**KIRKLEES METROPOLITAN COUNCIL
INVESTMENT & REGENERATION SERVICE**

Reference No:	2024/62/91176/W
Site Address:	8, West View, Paddock, Huddersfield, HD1 4TX
Description:	Erection of rear dormer
Recommending Officer:	Laura Yeadon

HOUSEHOLDER DELEGATED REPORT

Rev	Description	Date	Dr by	App by
original by JW	Date Created March 2024			
client name Mr Braham				
project 8 West View, Paddock, Huddersfield Internal Refurbishment and Loft Conversion				
drawing Proposed Plans, Elevations and Section				
drawing number T001		scale 1 : 50		@A1
		rev

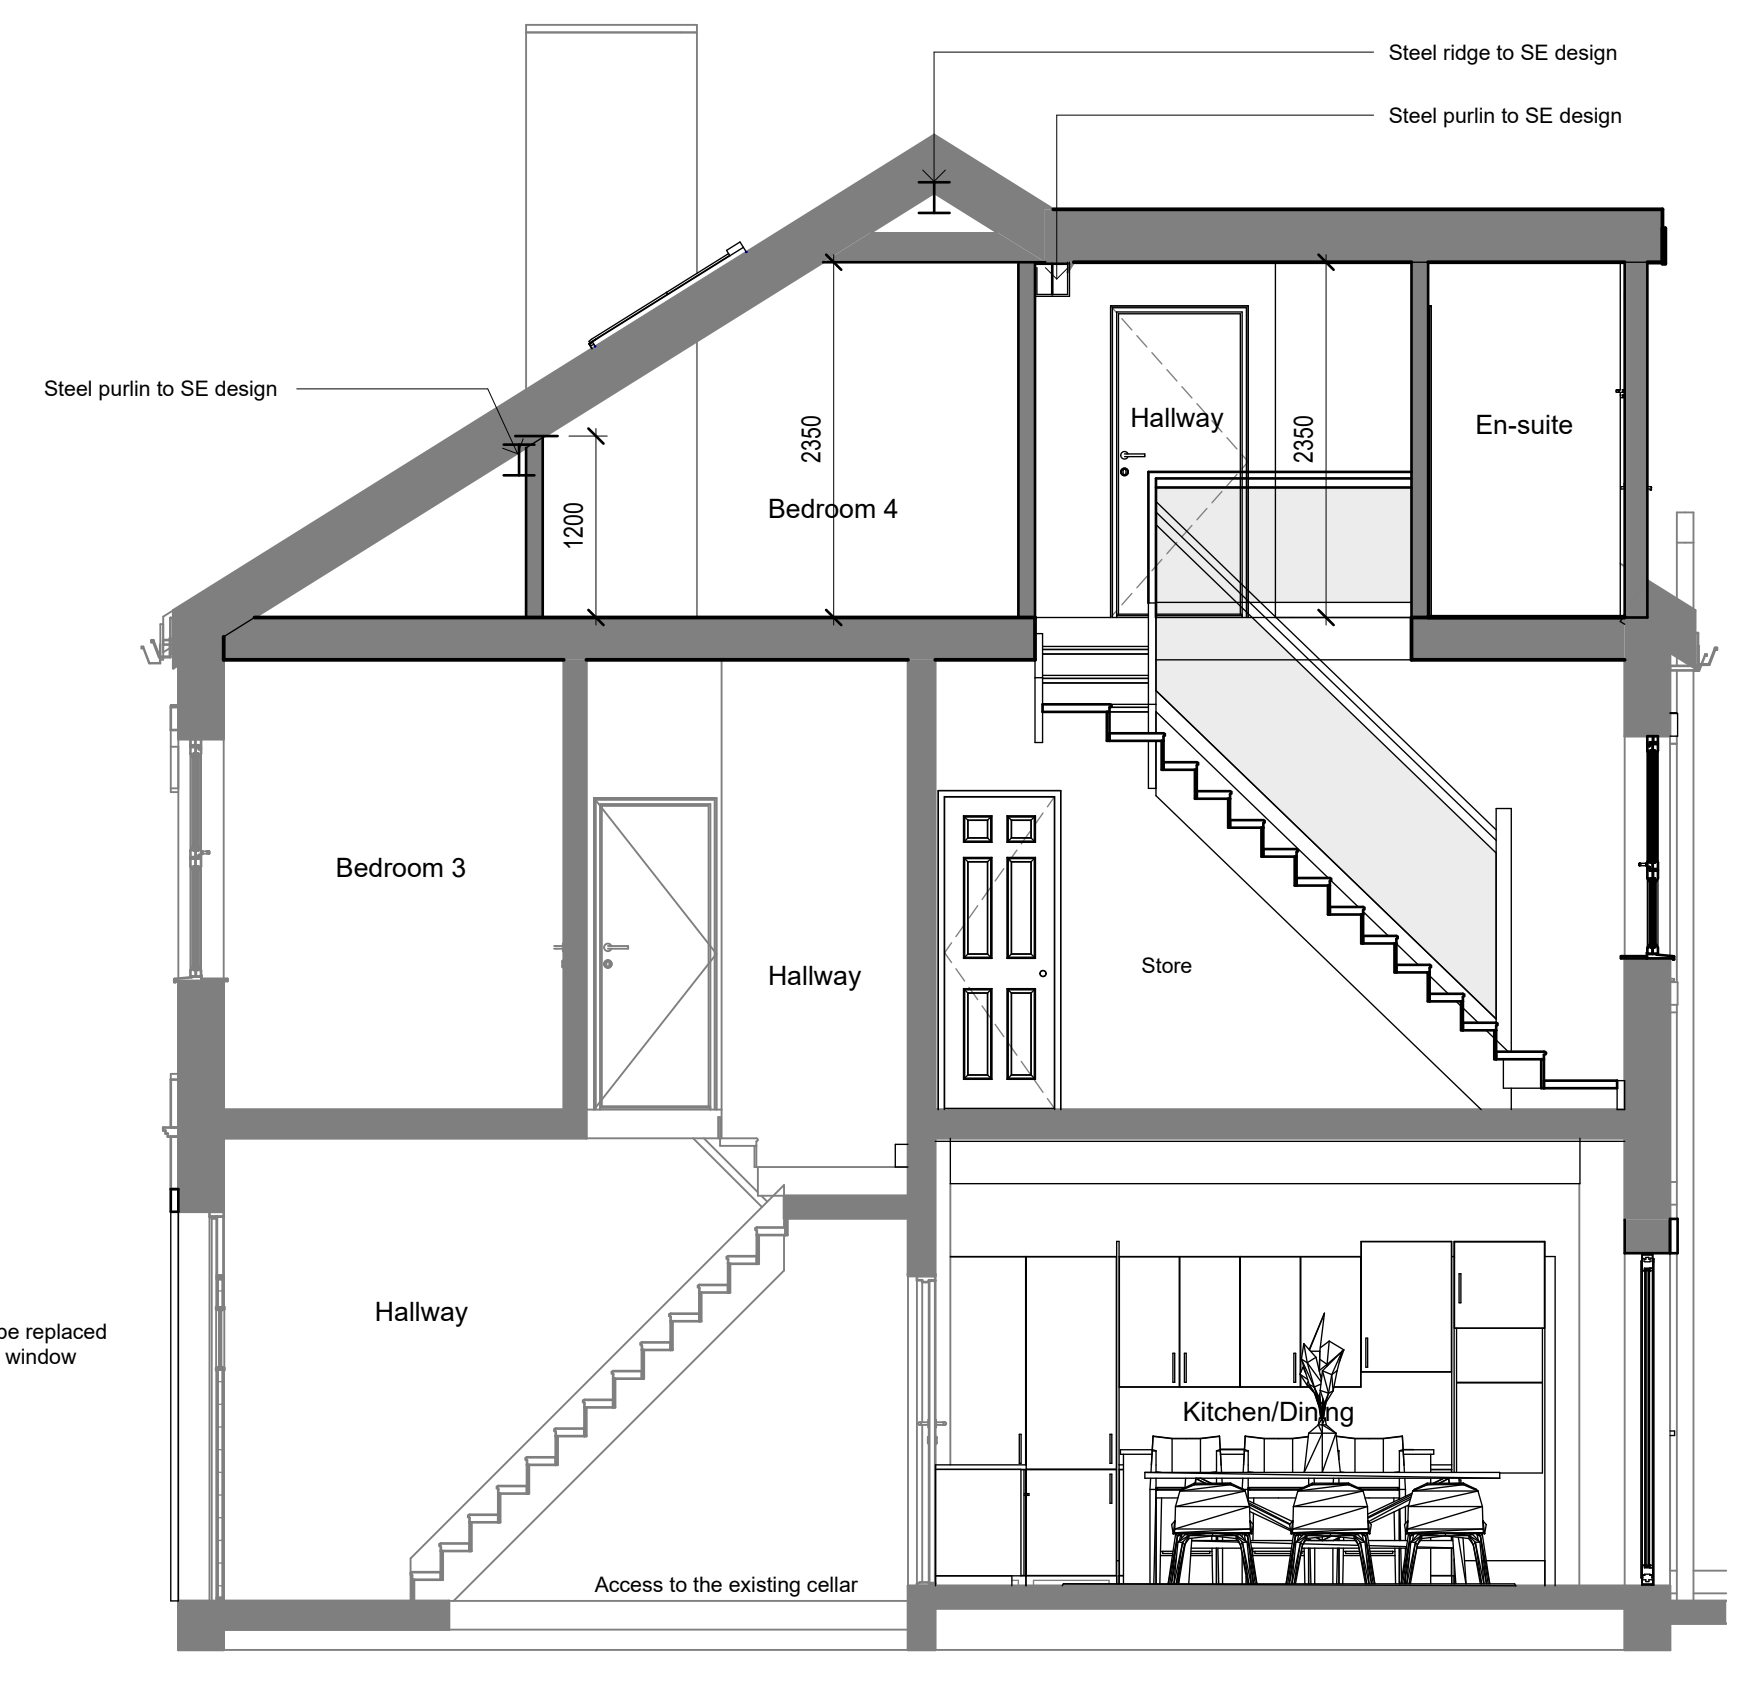
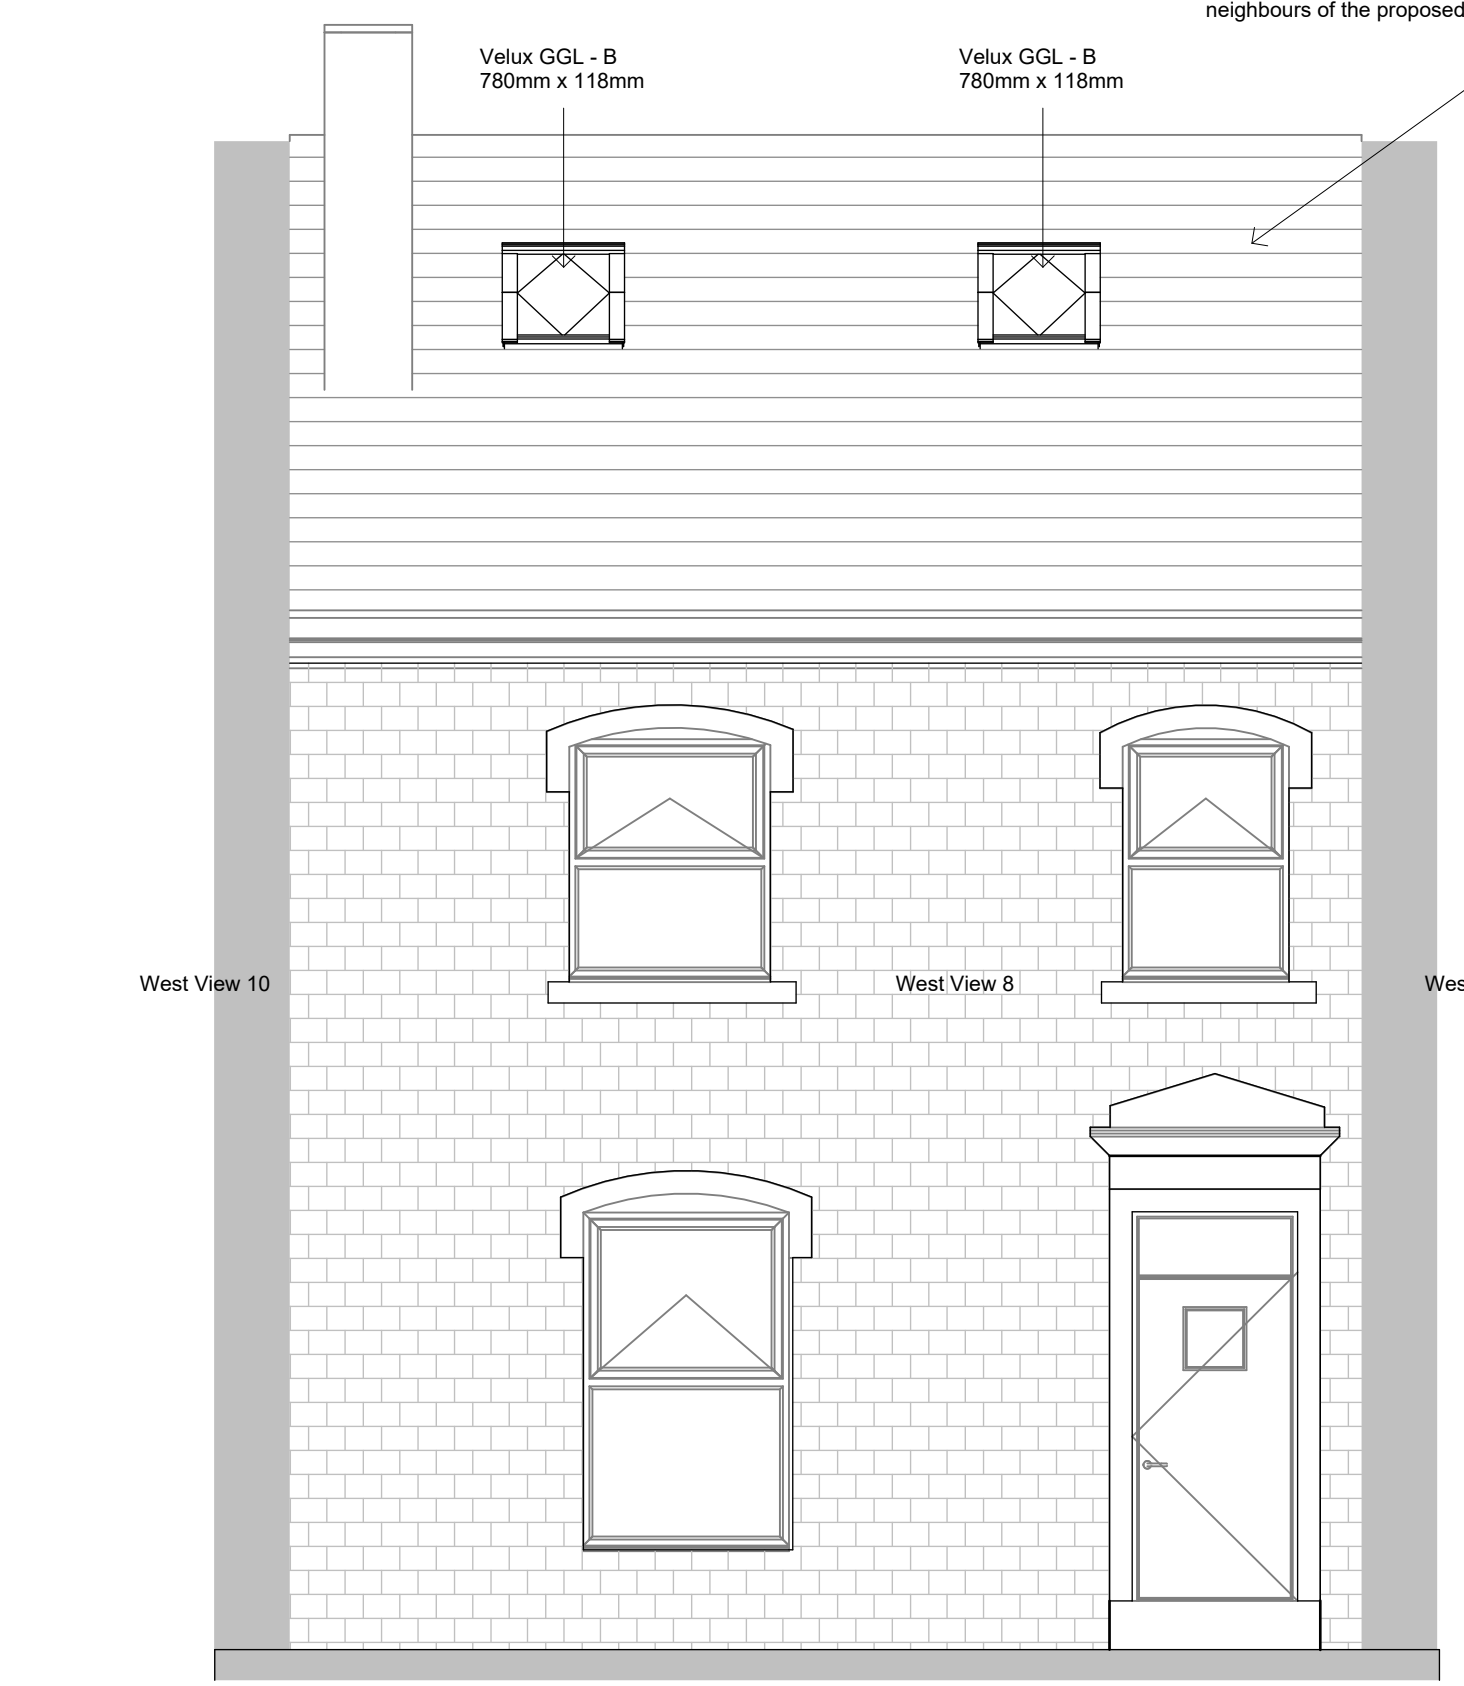
The proposed dormer would be 6.7m in width, 2.6m in height and 4m in projection being a total volume of approximately 35 m3. The proposed

construction materials would be composite clad panels for the dormer cheeks, concrete for the roof and uPVC for the windows.

Dormer extensions should:	<u>Yes - COMPLY</u>	<u>No - JUSTIFY</u>
relate to the appearance of the house and existing roof	Yes – set within the confines of the existing roof	
be designed in style and materials similar to the appearance of the existing house and roof	No – finishing materials composite cladding	Composite cladding typical material for dormer extensions – colour can be conditioned to be dark grey to match colour of the existing roof. – likely Permitted Development fall back position in this case.
not dominate the roof or project above the ridge of the house	No – the dormer is large within the rear roof slope.	However, the dormer would be set within the confines of the existing rear roof which can still be read – likely Permitted Development fall back position in this case
be set below the ridgeline of the existing roof and within the roof plane	Yes	
be aligned with existing dormer windows on neighbouring properties in the same roof plane where relevant		No – no other dormer openings within rear elevation street scene. Likely a PD fall back in place in this case.

Relevant key design principle (KDP) of the SPD, Policy in the Kirklees Local Plan and the NPPF	Further comments	✓ / X / N/A
Impact on the Local character and street scene	<ul style="list-style-type: none"> • KDP1 of the SPD • Policy LP24 Design (a) and (c) of the KLP • Chapter 12 NPPF 	Rear roof form within terraced row already interrupted with gabled roofs to rear of No's 4 and 6. Property hosts full permitted development rights	✓
Impact on original house	<ul style="list-style-type: none"> • KDP2 of the SPD • Policy LP24 Design (c) and (d) of the KLP • Chapter 12 of the NPPF 	Original roof form would be clearly visible	✓
Height, scale and massing	<ul style="list-style-type: none"> • KDP 1 and 2 of the SPD • Policy LP24 Design (a), (c) and (d) of the KLP • Chapter 12 of the NPPF 	Acceptable	✓
Facing materials and detailing	<ul style="list-style-type: none"> • KDP 9 of the SPD • Policy LP24 Design (d) (iii) of the KLP • Chapter 12 of the NPPF 	These can be secured by condition to ensure that the cladding is grey to match the existing roof	✓

3. The hereby approved dormer shall be either vertically slate hung with slates that in all respects match those used on the existing roof or be clad in dark grey cladding. The external materials of construction approved by this condition shall thereafter be retained.
